Subject: Bangor Savings Bank

Applicant: Bangor Savings Bank Letter of Correspondence #1

As you are aware, Bangor Savings Bank is under Level III Site Plans Review for its proposed facility at 20 Marginal Way in Portland. As you are also aware, the project has gone to the City Council and received approval of a text amendment, allowing a bank drive thru in a building less than 20,000 sf as a conditional use. Throughout the process, there have been numerous conversations between the project team and City Staff. At this time, we are providing the City with revised plans based upon the comments received from City Staff. This letter is provided to summarize the changes to the plans and respond to comments received from staff in an email from you dated June 8, 2015. For ease of review, the comments are provided followed by our response.

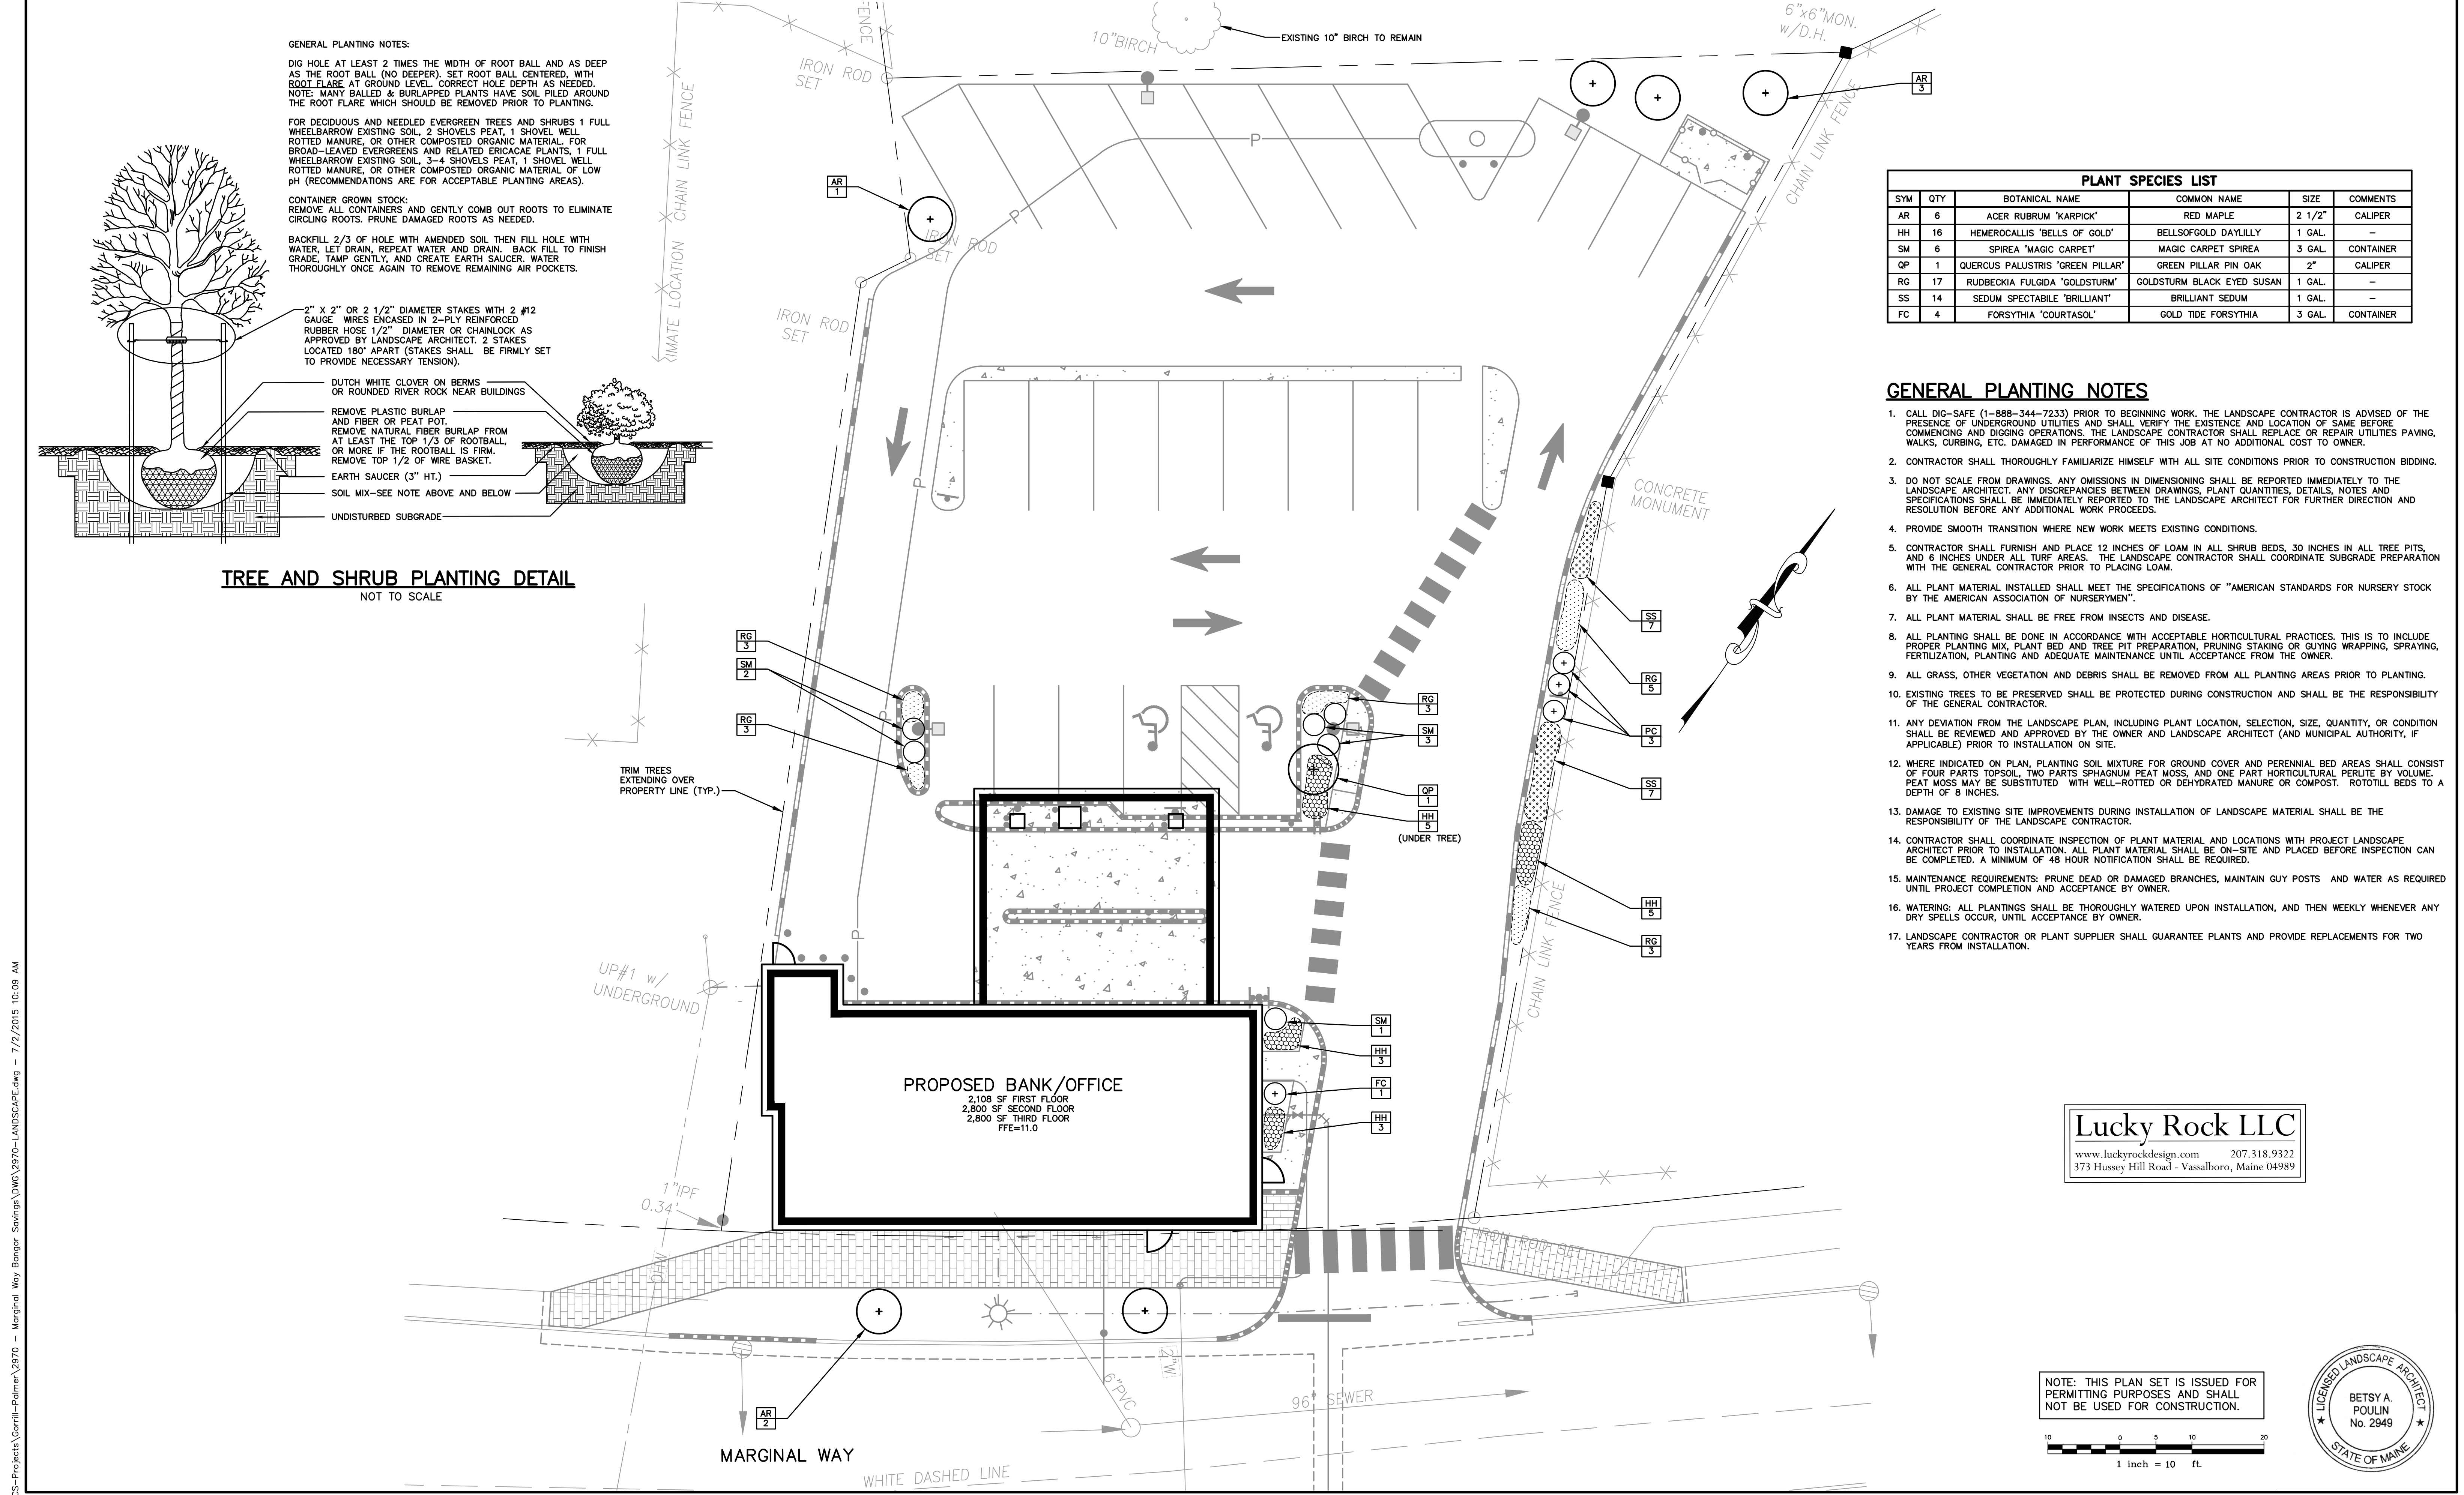
Comment: Re Landscaping: We would like to see landscaping (mostly trees) along the east side of the drive (along the existing chain link fence), along the rear boundary and in the parking lot islands. In order to free up more land for these planted areas we have the following suggestions that are OK with the Traffic Engineering reviewer:

- O Narrow the drive for the whole of its 2-way length to 22 feet in width (also OK from the Fire Dept viewpoint);
- o Reduce the paved area in "middle" area near the handicapped spaces and 2 way access to central parking;
- Have compact parking spaces (for employees, so low turnover) along the entire rear "angled" row of parking (a waiver for the larger % of compact spaces is supported);

Response: These items were further discussed with City Staff at a meeting on June 17, 2015. It was agreed that a portion of the access drive would be reduced to allow the planting of smaller items, such as daylilies, along the east side of the drive. Ornamental Pear trees were placed along the rear of the site where space was available. The parking spaces associated with the barrier free spaces were also shifted slightly to allow a larger end island for planting of additional day lilies.
